Subject: Arun Conservation Area Advisory Panel comments on applications

The **Arun Conservation Area Advisory Panel** wish the following comments to be taken into consideration in the determination of the applications:

WA/103/25/HH - Gable House, The Street, Walberton

Proposed Section

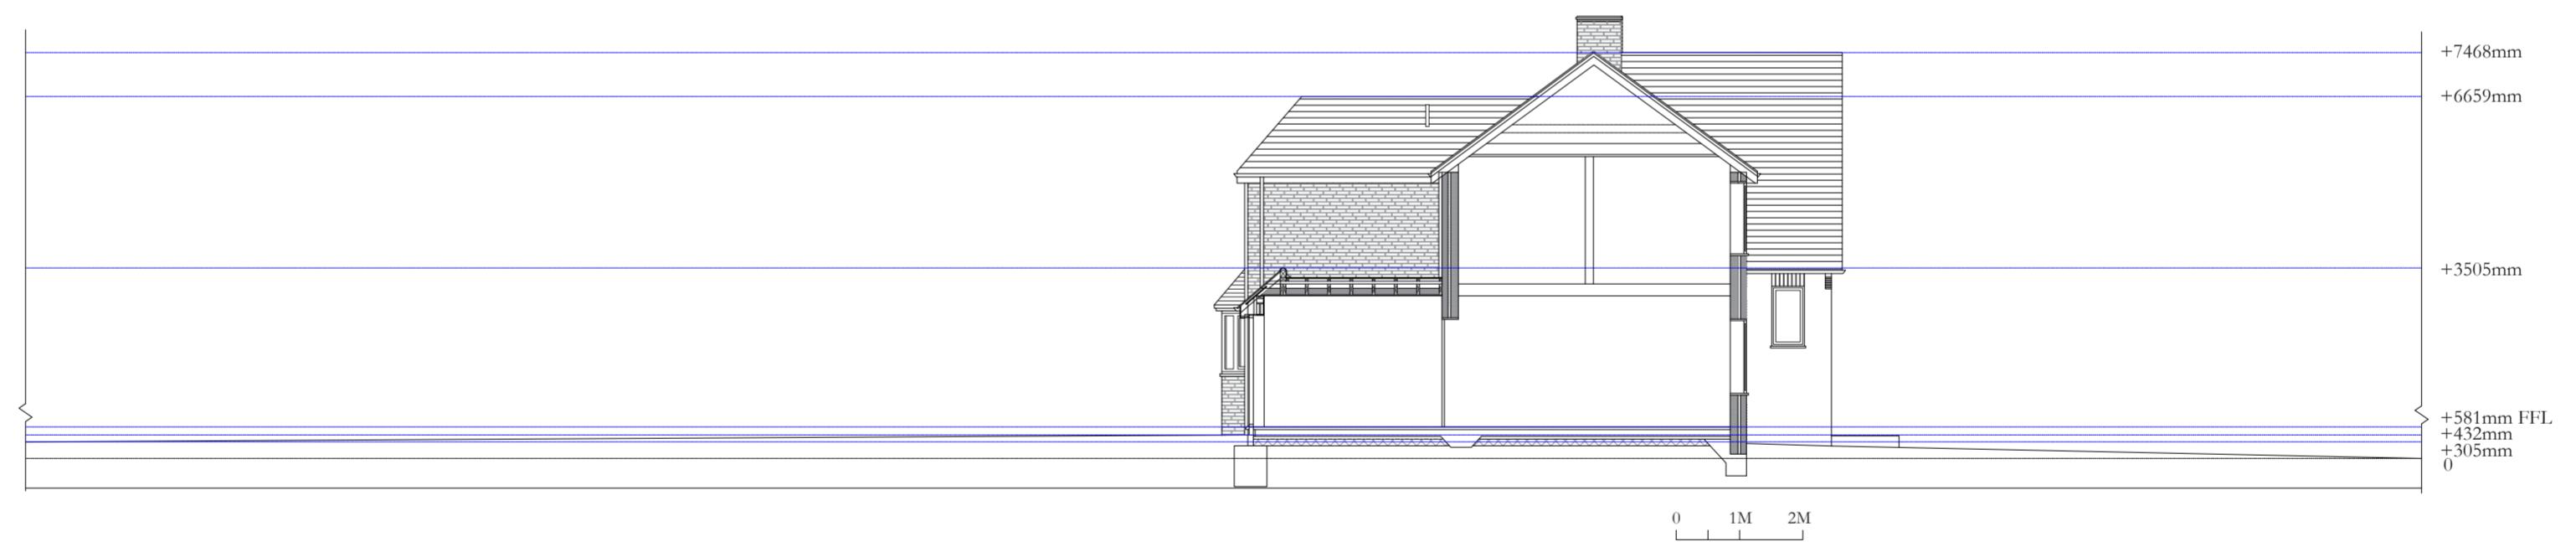
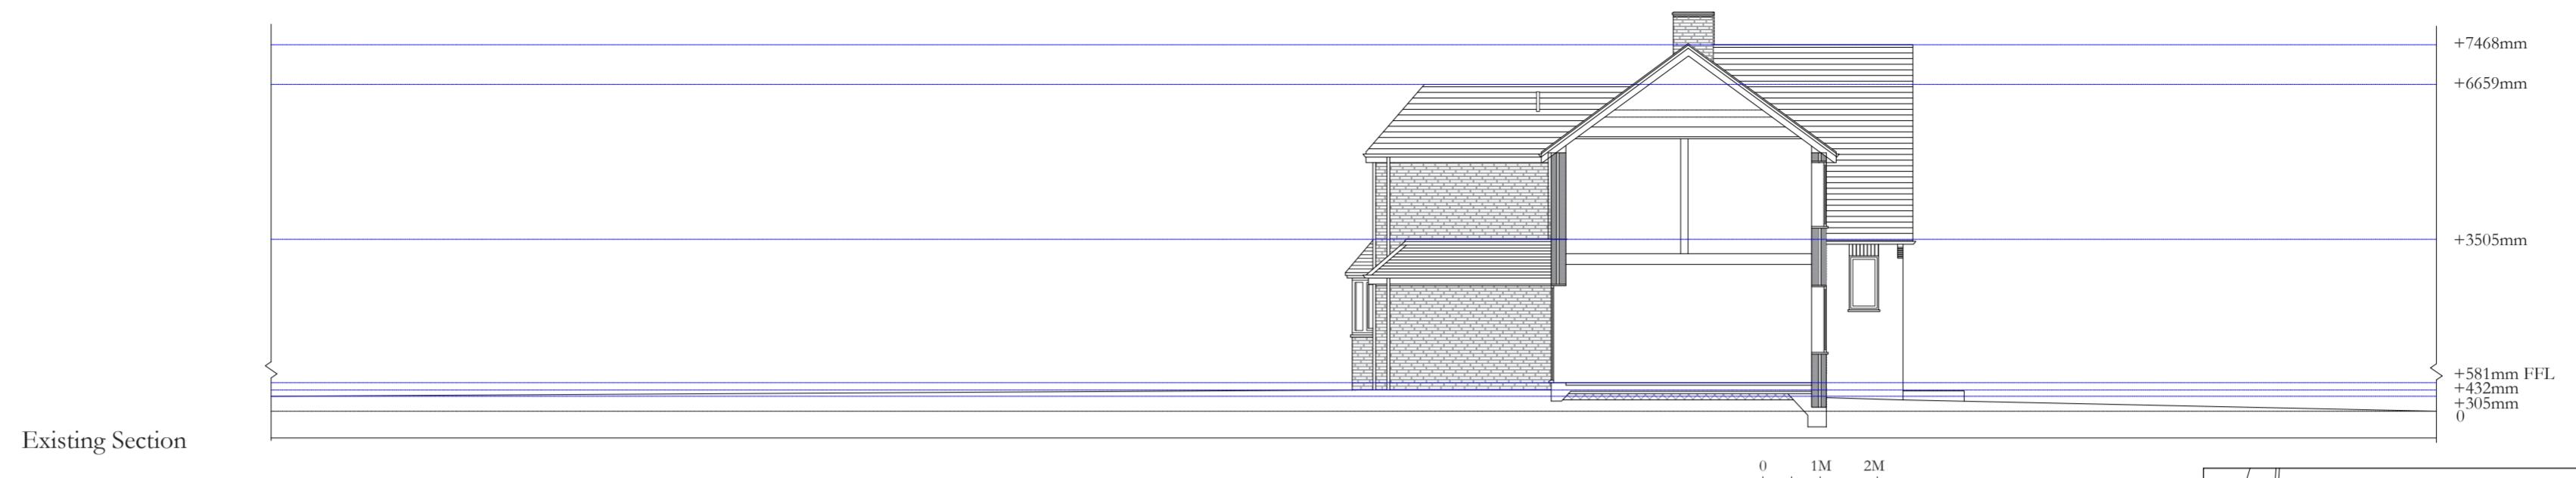
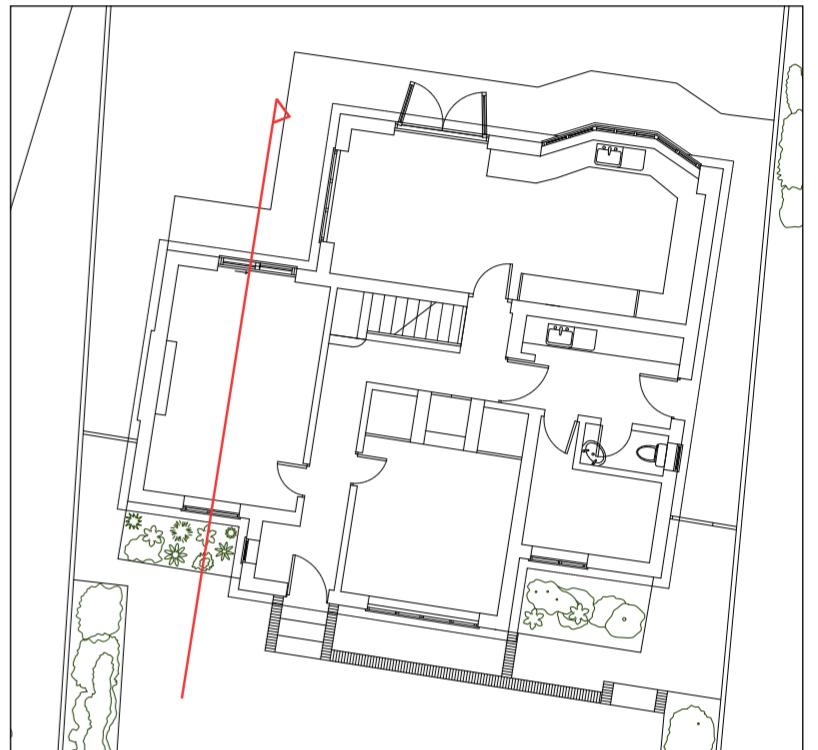
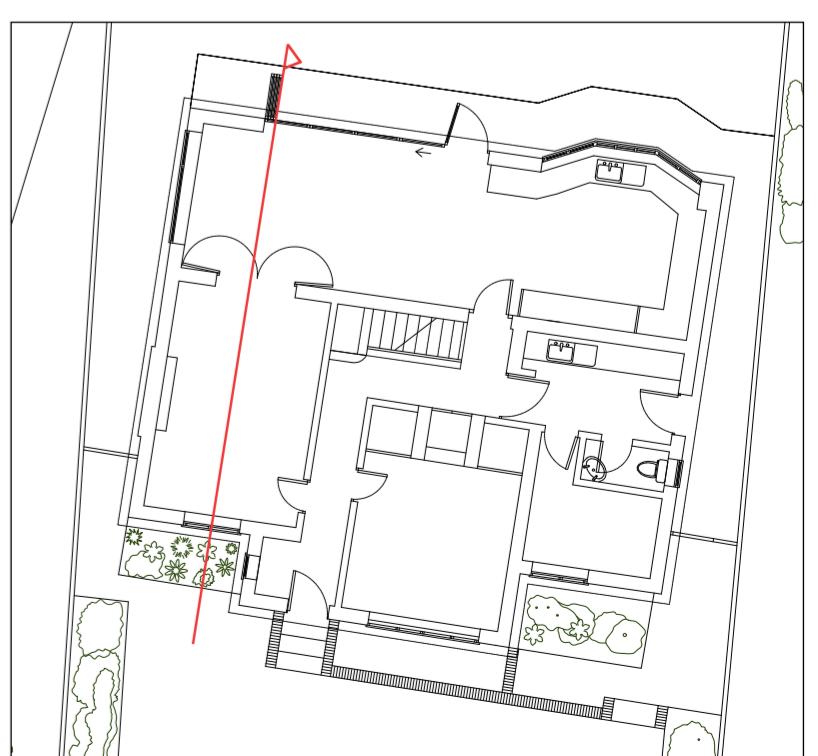
No elevational plans were available at the time that the Panel considered the application.

However, given the height and proposed location of the extension at the rear of the property, there is unlikely to be any adverse effect on the character or appearance of the conservation area.
